Subject: Rezoning Petition Review

Rezoning Petition #: 22-078

Location of Property: Approximately 7.41 acres located on the northeast side of W Trade St, west of Brookshire Fwy and east of Rozzelle's Ferry Rd.

SCALE: NORTH  
VERT: HORZ:  
SHEET TITLE:  
**DEVELOPMENT STANDARDS**  
SHEET NUMBER:  
**RZ-03**

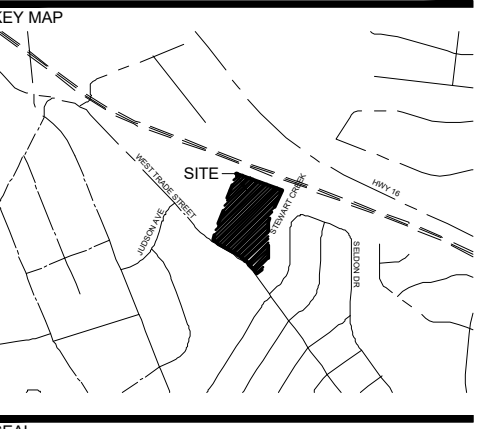
Please include the following note under Environmental Features: *“Development within any SWIM/PCSO Buffer shall be coordinated with and subject to approval by Charlotte-Mecklenburg Storm Water Services and mitigated if required by City ordinance. Petitioner acknowledges intermittent/perennial stream delineation reports are subject to review and approval upon submission of development plans for permitting and are not approved with rezoning decisions.”*

This property drains to Irwin Creek, which is an impaired/degraded stream, and may contribute to downstream flooding. This project has the opportunity to mitigate future impacts to this stream, therefore, Storm Water recommends placing the following notes on the plan:

(I) Storm Water Quality Treatment

For defined watersheds greater than 24% built-upon area (BUA), construct water quality stormwater control measures (SCMs) designed for the runoff generated from the first 1-inch of rainfall for all new and redeveloped BUA associated with the project. SCMs must be designed and constructed in accordance with the Charlotte-Mecklenburg BMP Design Manual.

(II) Volume and Peak Control

For defined watersheds greater than 24% built-upon area, control the entire volume for the 1-year, 24-hour storm for all new and redeveloped BUA associated with the project. Runoff volume drawdown time shall be in accordance with the Charlotte-Mecklenburg BMP Design Manual.

For commercial projects with greater than 24% BUA, control the peak to not exceed the predevelopment runoff rates for the 10-yr, 6-hr storm and perform a downstream flood analysis to determine whether additional peak control is needed and if so, for what level of storm frequency, or if a downstream analysis is not performed, control the peak for the 10-yr and 25-yr, 6-hour storms.

For residential projects with greater than 24% BUA, control the peak to not exceed the predevelopment runoff rates for the 10-year and 25-year, 6-hour storms or perform a downstream analysis to determine whether peak control is needed, and if so, for what level of storm frequency.
